Consultation Response: Kirklees Council Environment Unit

Lock Street Thornhill Dewsbury outline application for 106 dwellings 2013/90249

LANDSCAPE

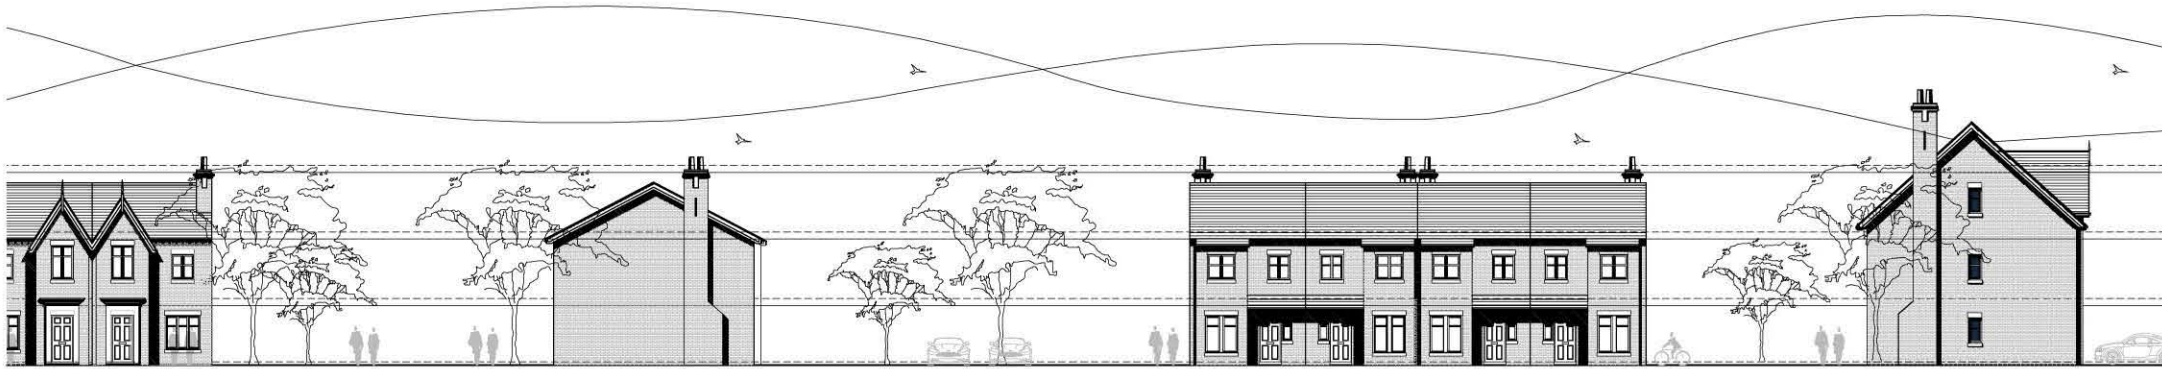
The value of this ecological network has previously been compromised to some degree by habitat fragmentation and artificial lighting. Even so, it is recommended in the report that these woodland corridors are retained and enhanced with areas of native species planting of trees and shrubs within the development. We support these proposals. However, it appears from the information provided about the development that the woodland corridor along the south western boundary is to be removed (the woodland in the canal corridor is actually outside of the proposed development site) and developed.

This loss of semi-natural habitat and ecological connectivity is unacceptable and contrary to guidance in the NPPF which sets out how development should aim to enhance ecological networks. The application as it stands should be refused on this basis.

It is important that measures are taken to ensure artificial lighting does not spill into the semi-natural corridors.

A landscape management plan should also be produced detailing how the retained semi-natural areas should be managed in the longer term. Resources should be provided to implement the plan.
